Your Ref: OWPC15191
Our Ref: FG/122/17/HH 27-07-2017
Please ask for:
Andrew Wood

Replacement of existing single storey garage & outbuildings with single storey side extension & two storey rear extension - Amendment following FG/178/16/HH
5 Sea Drive Ferring

drawing
Planning Applications
Proposed First Floor Plan

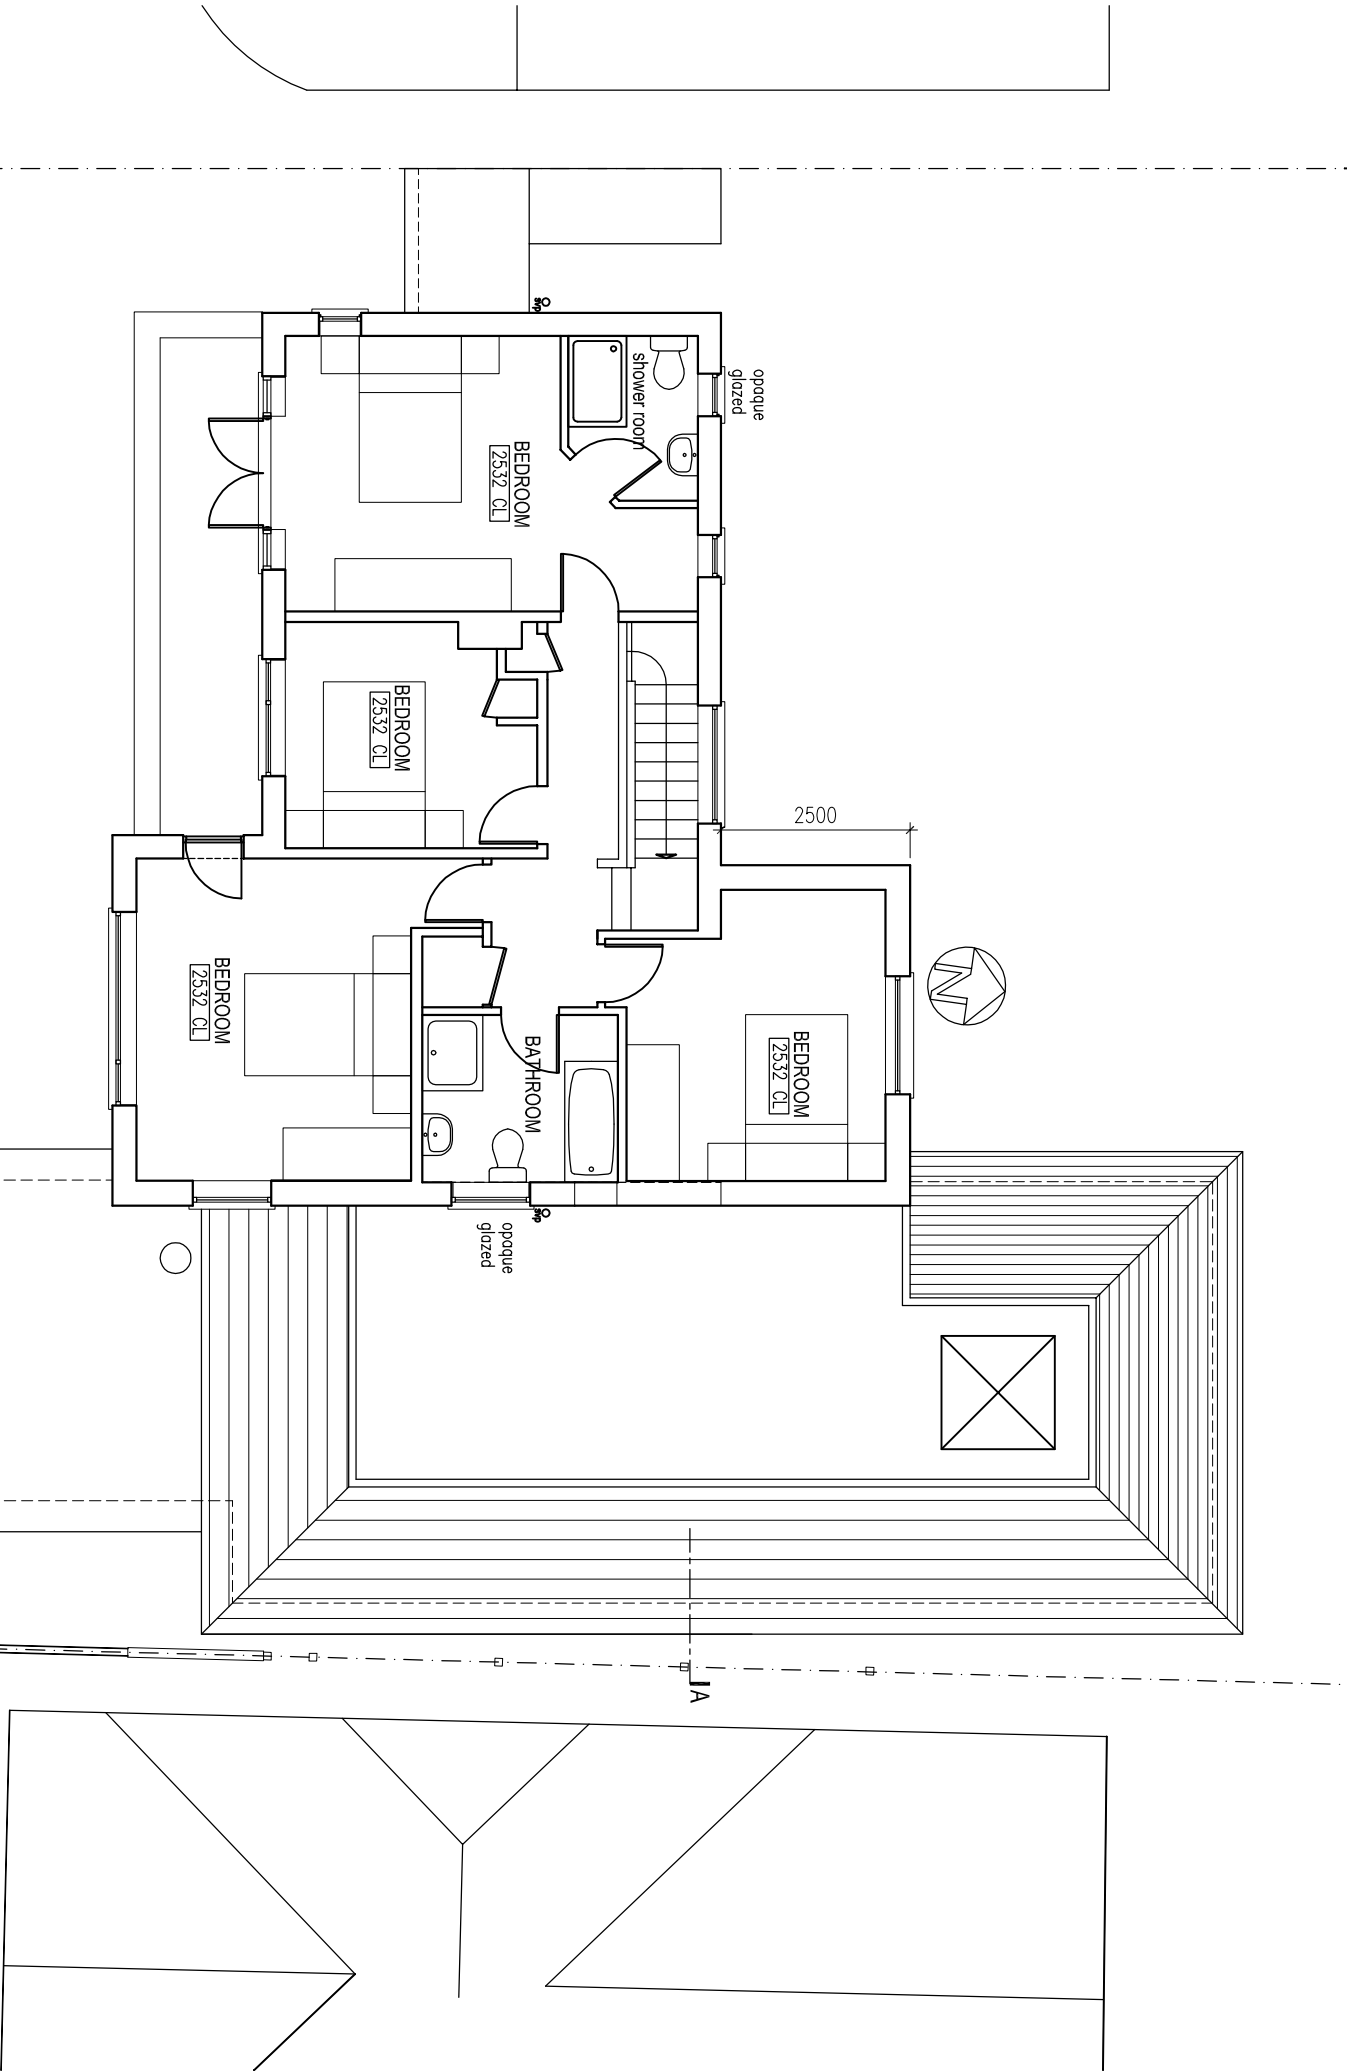
Please provide details of how the rear 2 storey extension affects the light to the only window in our West facing bedroom, with respect to the 45 degree rule, as i note this detail is not shown on the plans.
